Freedom Forever
Planset Revision Letter

11/26/2024
REV #2

Attn. County of Harnett (NC):

RAYMOND PATTERSON
118 OLEANDER LANE

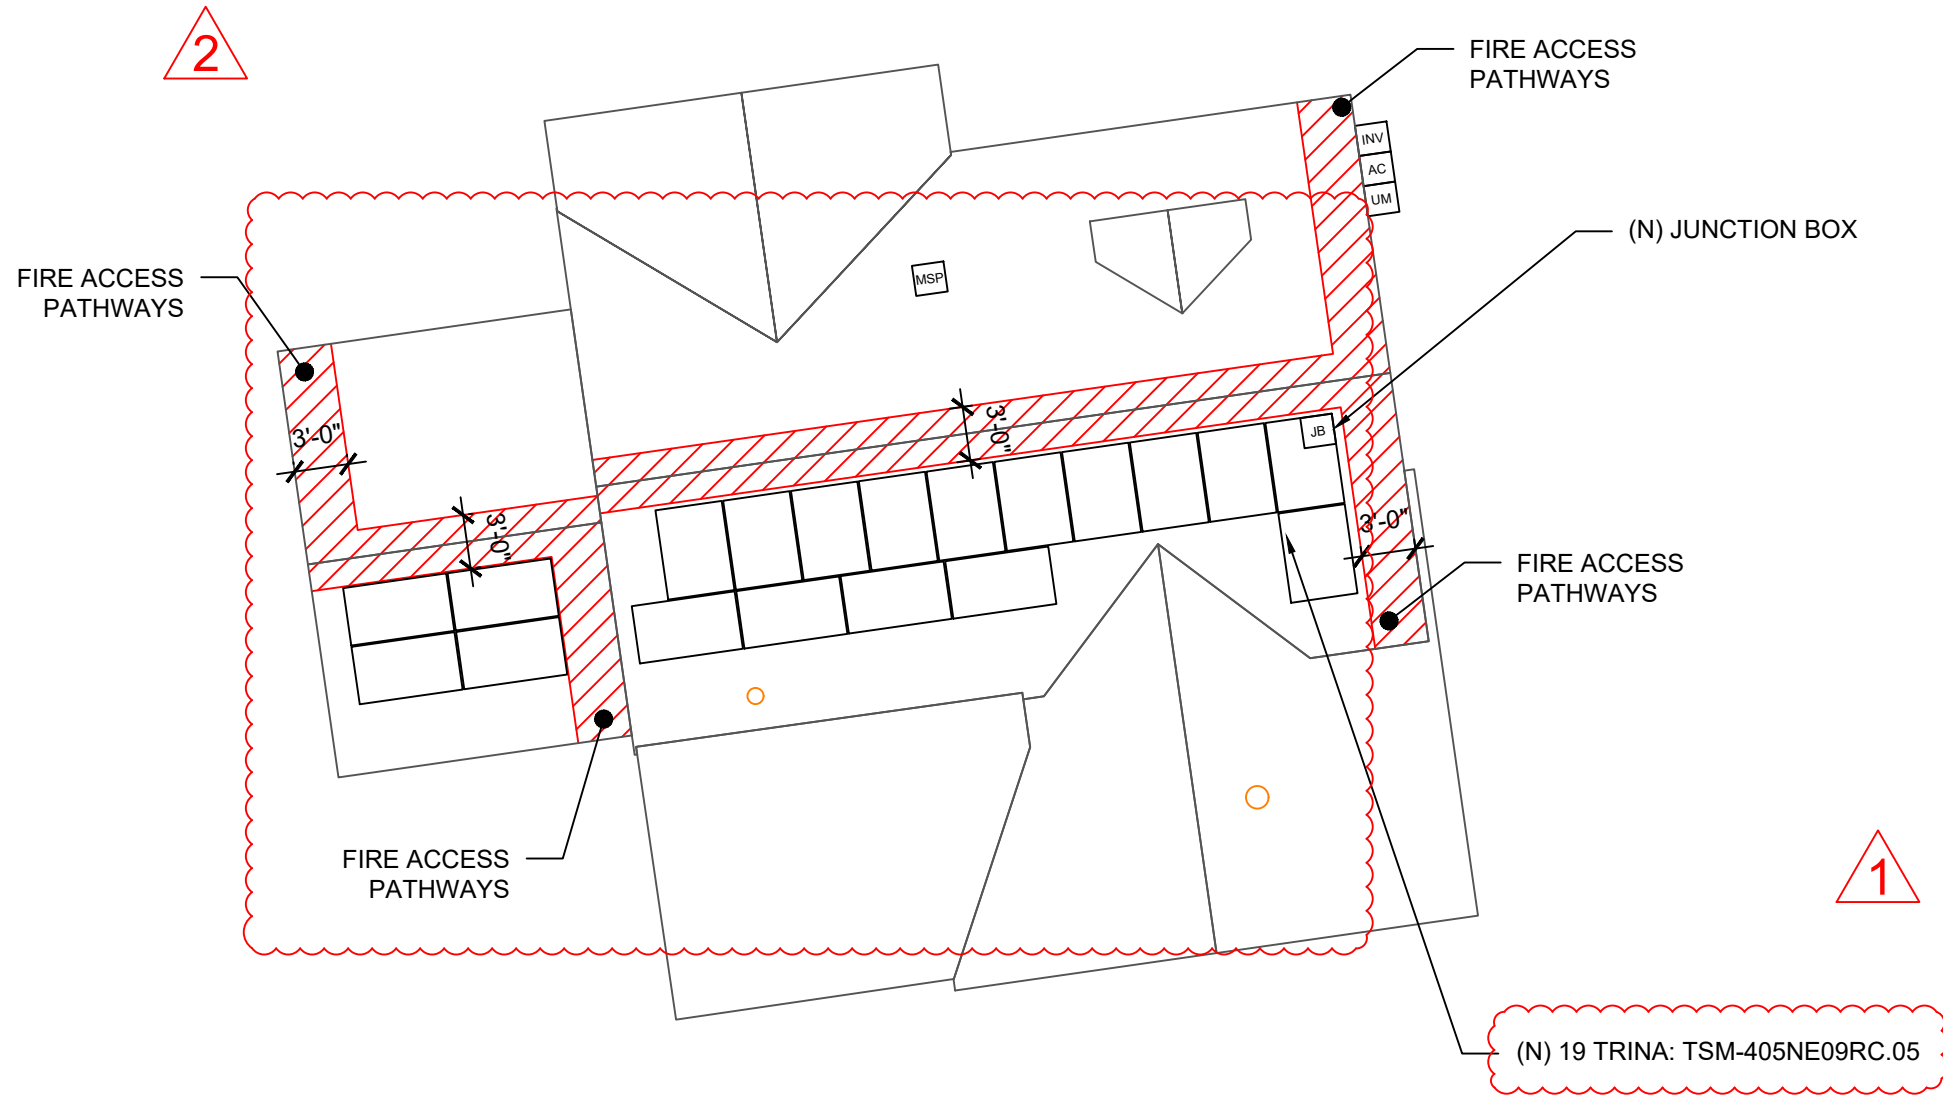
REV 2

Layout changed as requested.

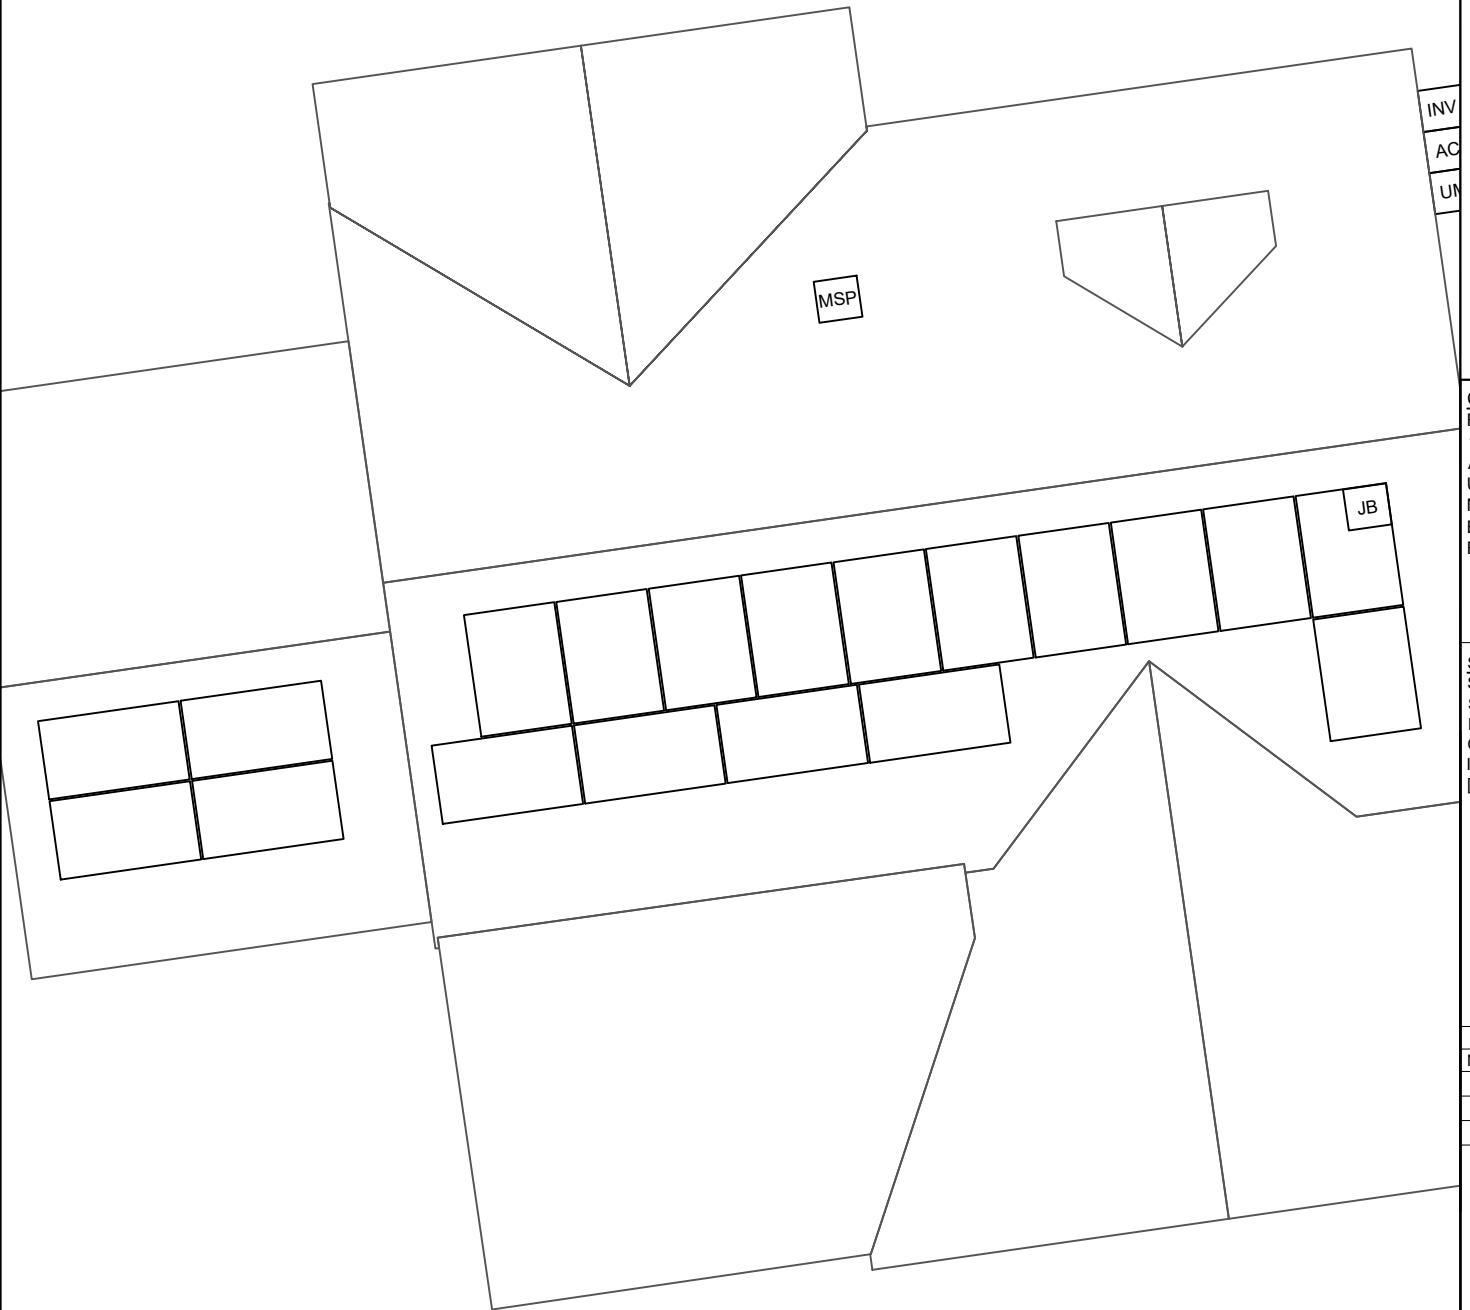
REV #1

MODULE SWAP SILFAB 430 TO (19) Trina: TSM-410NE09RC.05 AS PER INSTALL
